Fwd: Comments re: MMC 22 Bramhall site plan

On Saturday, December 15, 2018 at 5:37:17 PM UTC-5, Christian MilNeil wrote:

To the planning board and staff,

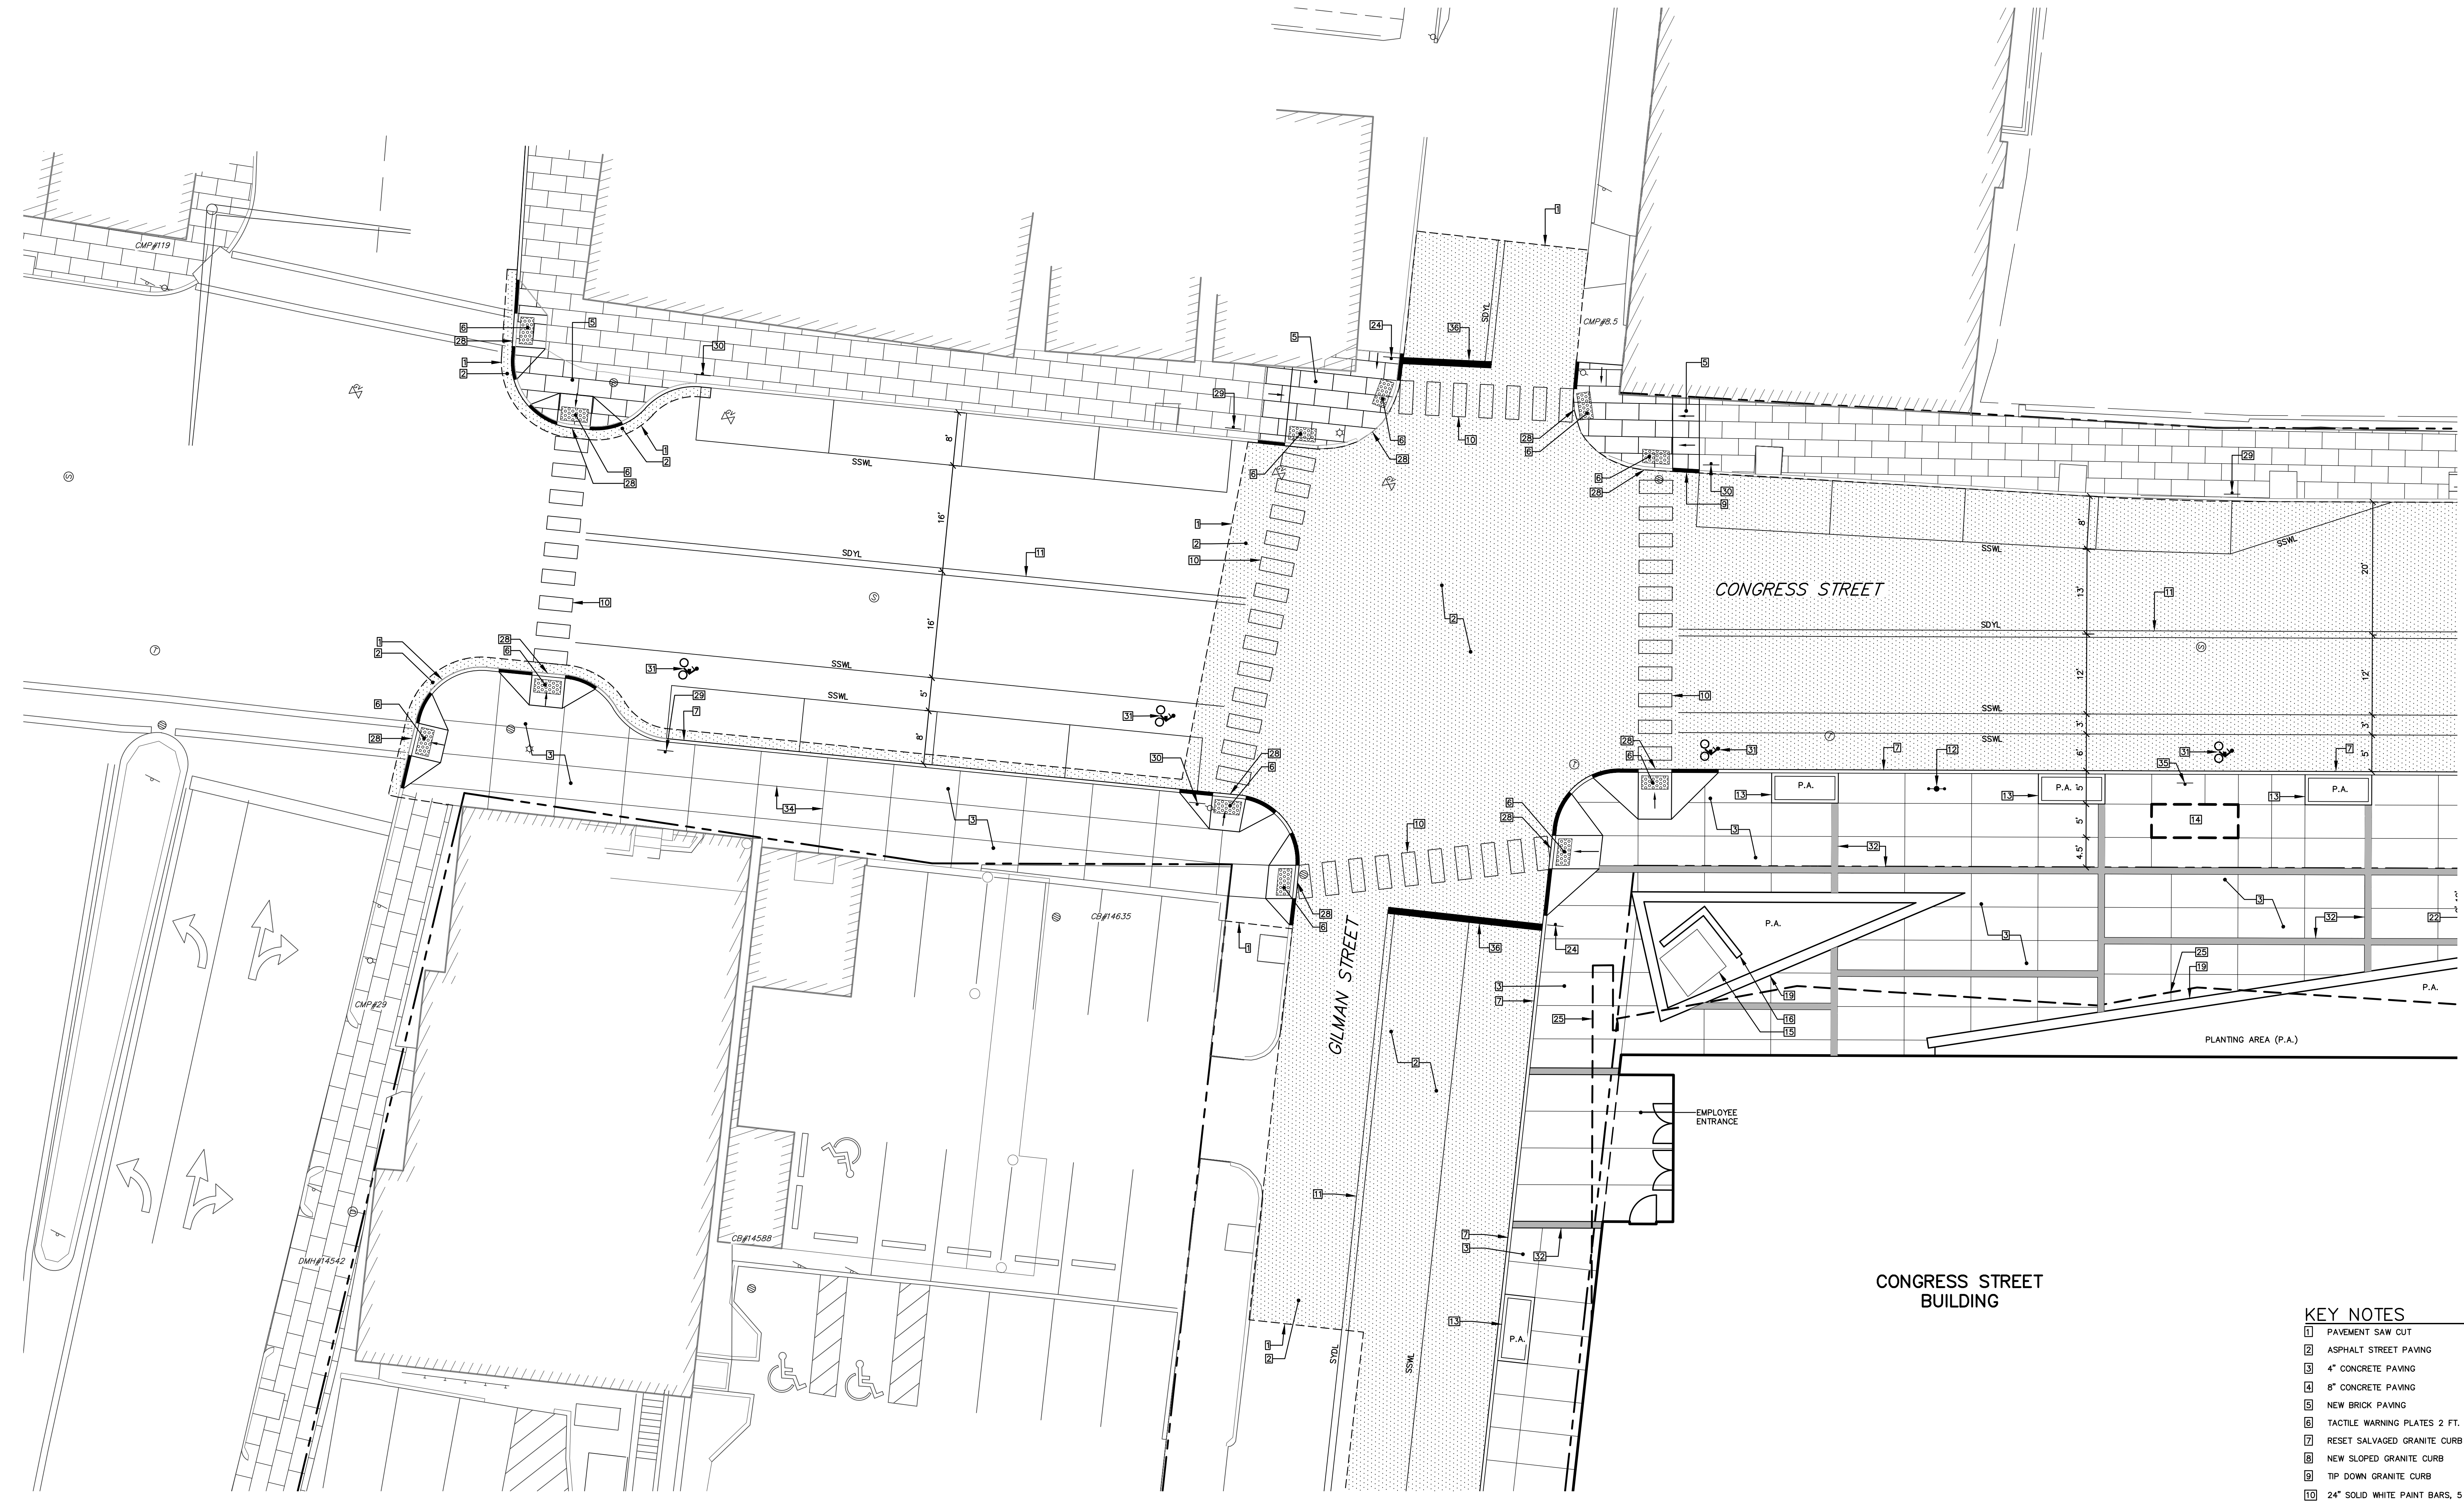
- I appreciate and agree with the planning staff's insistence on making sure Gilman Street has sidewalks on both sides of the street – with the new addition, Gilman will be a busy pedestrian route and deserves to be as complete as other city streets in the neighborhood.
- I also strongly endorse the addition of a climbing bike lane up Congress Street. This is a very frequently used bike route – essentially the main entrance to the peninsula for cyclists arriving from the west, including from the Portland Transportation Center.
- However, I am concerned about the bike lane's interactions with potentially high volumes of right-turning traffic entering and exiting the main entrance loop and the visitors garage. These conflict points raise the possibility of right-hook crashes, where turning cars don't look for bikes using the lane to their right.

In those driveway crossings, I'd like to suggest the city and the applicant look into using high-visibility conflict zone markings, similar to markings that have been installed on Park Avenue, at the Exit 6 ramps and on Commercial Street at the Beach Street intersection (this image is from the [City of Seattle's Right-of-Way Improvements Manual](#)):
